**Consultation Response from KC,  
Lead Local Flood Authority**

**2022/92471 Heckmondwike Hub Bus Station, Royle Fold, Heckmondwike, WF16 0HW**

**Redevelopment of Heckmondwike Bus Station including a new concourse building with waiting room, Changing Places WC, driver offices, 6 No. bus stands, landscaping, and associated works**

**Date Responded: 23<sup>rd</sup> August 2022**

TITLE: **DRAINAGE PROPOSALS**

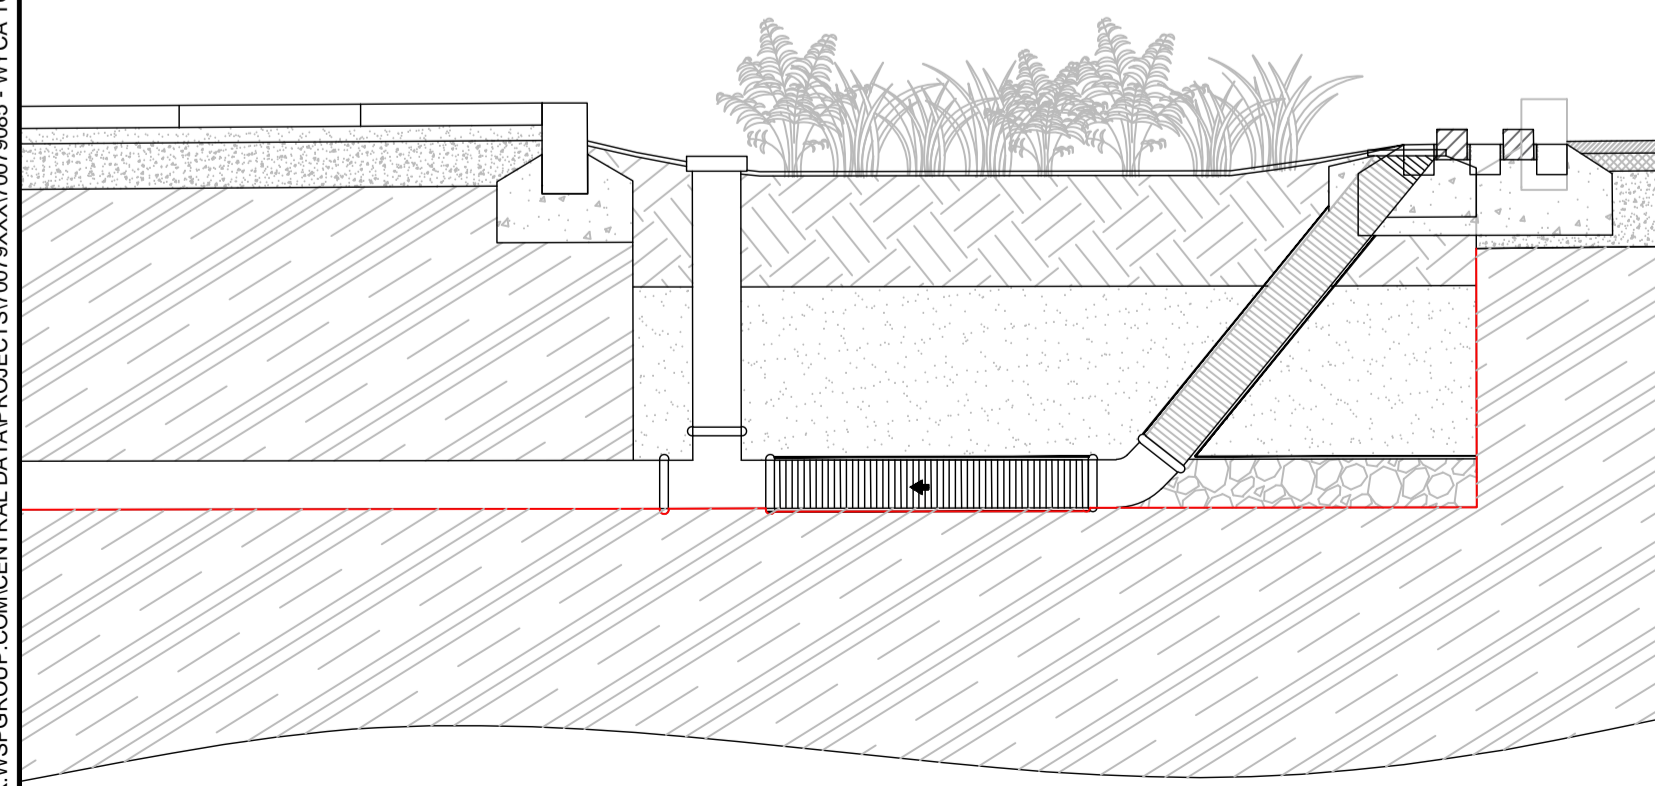
The use of generic 'SUDS' is mentioned on a drawing but is not adequately explained what this is and how it will contribute to meeting policy requirements
